**From:** Bloomer, David <David.Bloomer@lancashire.gov.uk>  
**Sent:** 20 December 2019 14:29  
**To:** planning  
**Subject:** Hawthorne Farm Clitheroe, app 1104

I have just had a quick look at this one and there are a few areas that need further clarification.

'THE DELAMARE' | PLANS AND ELEVATIONS | 2 STOREY | 3 BED | GARAGE: 5830 | FOOTAGE: 993 | SCALE: 1:100

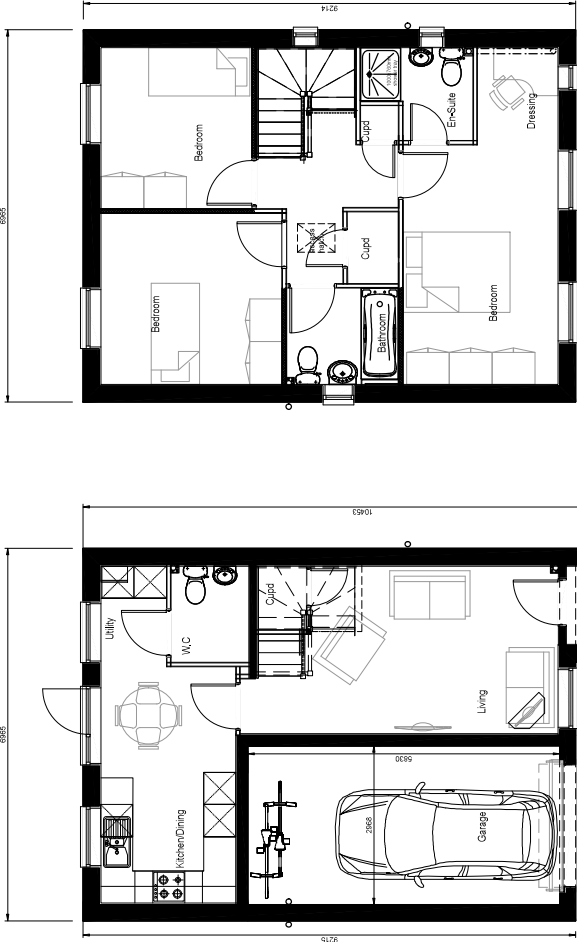
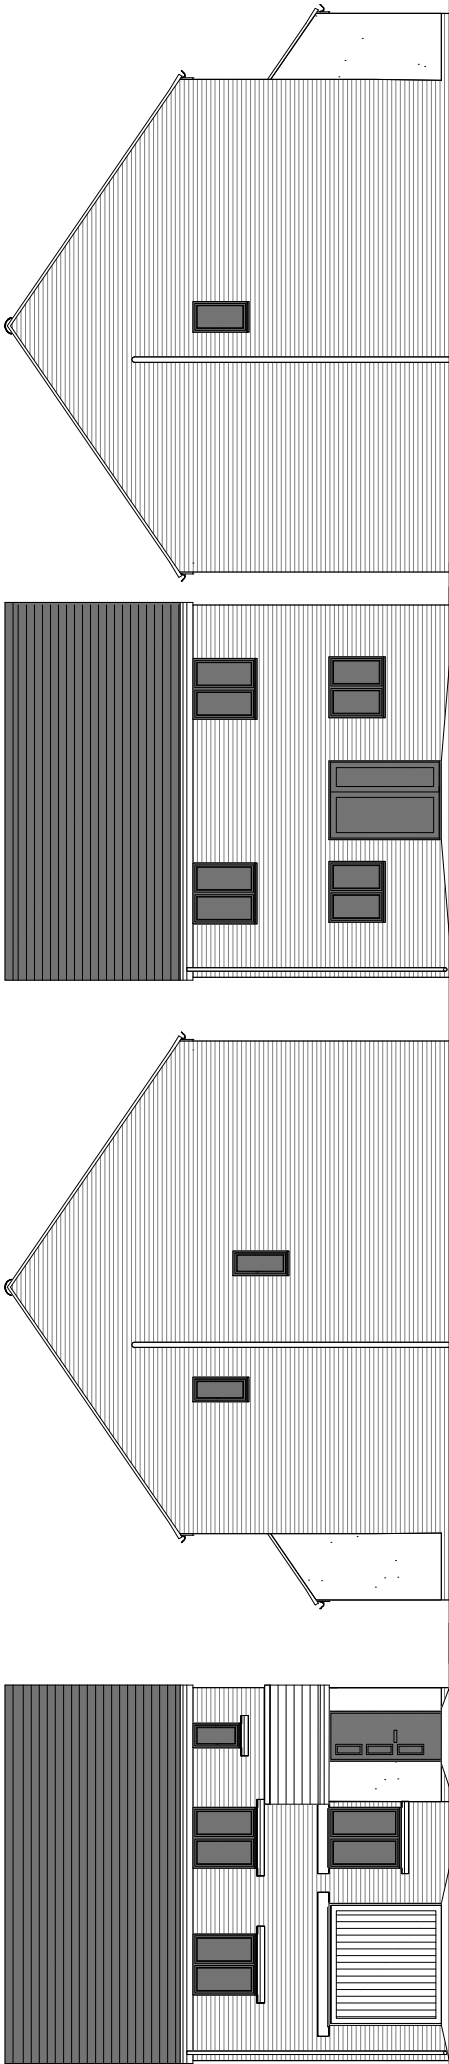
2 The garage dimensions fall below the accepted 6m x 3m minimum dimensions and cannot therefore be considered as bona fide parking spaces. This being the case, the parking provision would fall below expectations.
